Ribble Valley Borough Council  
By email

Your ref 3/2024/0476  
Our ref DC/24/1835  
Date 19-AUG-24

**Location: Plane Tree Farm Chipping Road Chaigley BB7 3LT**  
**Proposal: Proposed general purpose open-sided agricultural building 18.28m long, 9.14m wide,**

Drawing file: planx_downloads / 24_0476_Location_of_water_main.pdf

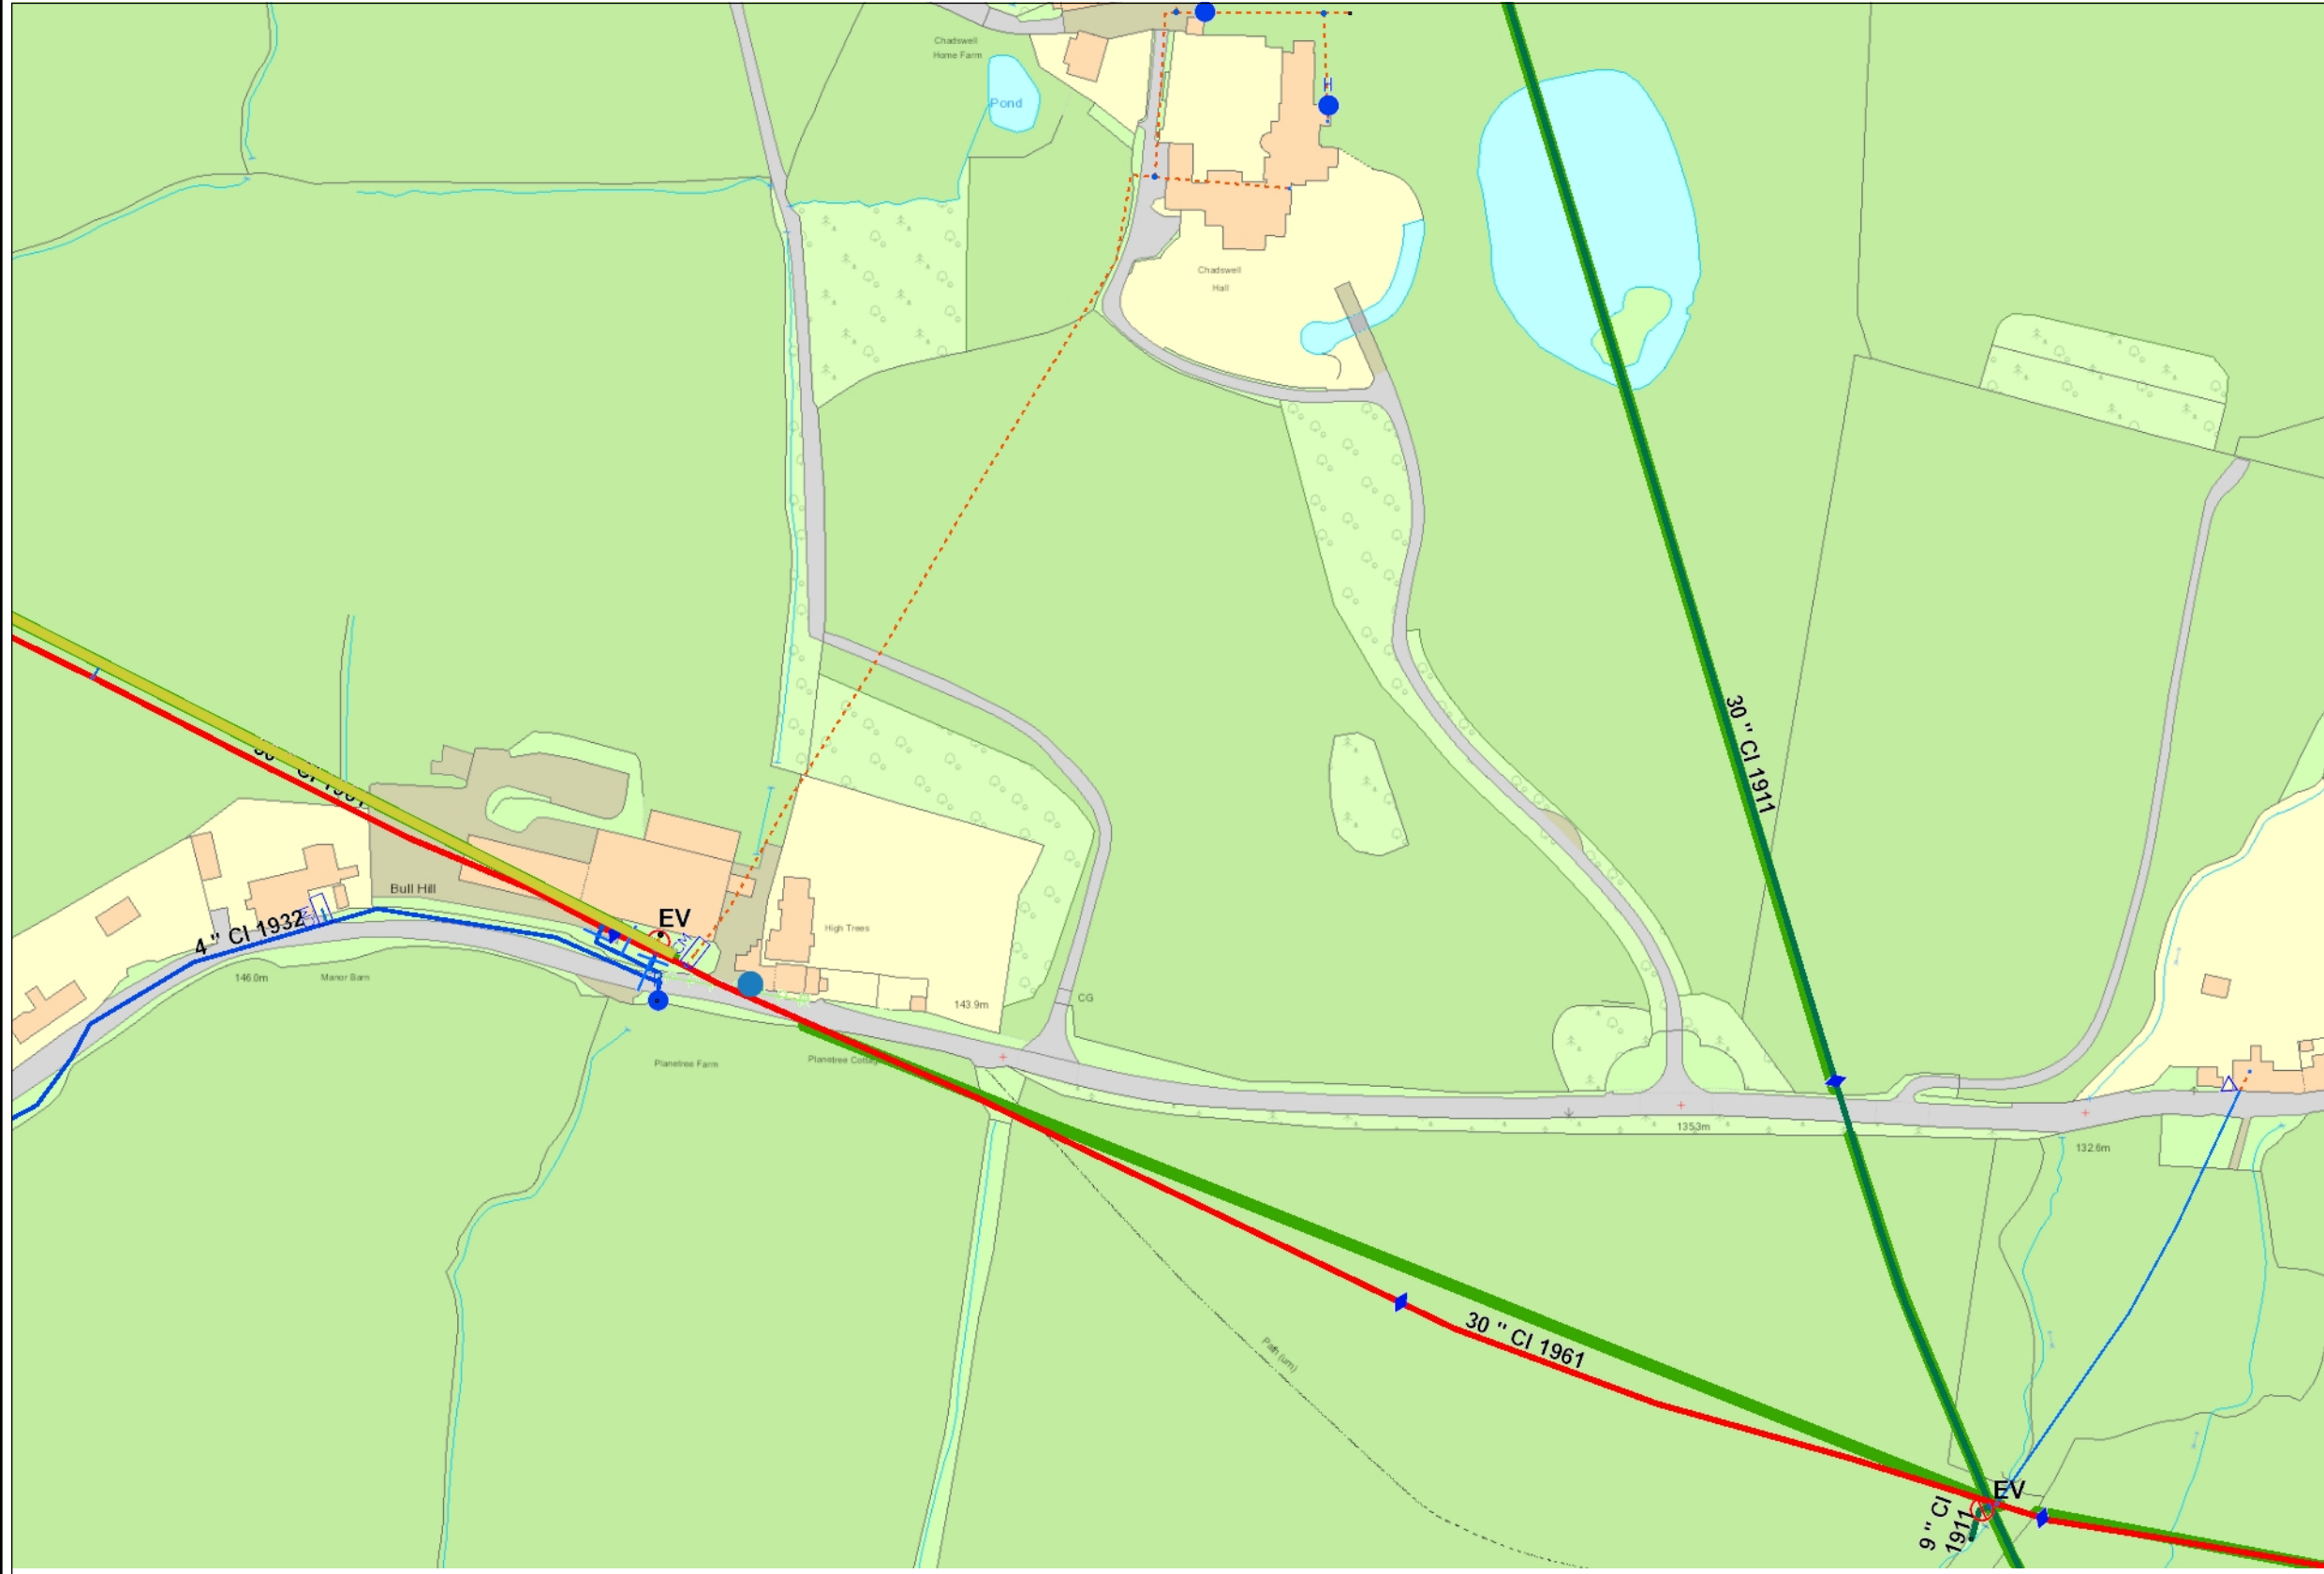
A strategic large diameter trunk main is located in the vicinity of the site. It must not be built over, or our access to the pipeline compromised in any way. We require an access strip as detailed in our 'Standard Conditions for Works Adjacent to Pipelines', which can be found on our website:

Based on the information currently available, it is unclear whether sufficient distance is provided between proposed development features and our water asset(s). We recommend the applicant contacts our Water Developer Services team to ensure existing water assets, along with our required access widths, can be accommodated in the proposed layout. If the applicant fails to investigate and resolve any concerns prior to a positive determination, there is a risk that as the scheme progresses, the applicant, or any subsequent developer, may discover that their plans are not implementable in their existing form or that diversion of assets is required.

If the Local Authority requires any additional comment on the acceptability of the proposed layout from United Utilities, we will require a detailed site layout plan, which overlays the PROVEN location of the water asset(s) in relation to any proposed development (including walls, fencing, parking etc.). In this scenario, we will require evidence to show that the location of the pipeline(s) has been confirmed by site specific survey, a copy of asset maps will not suffice.
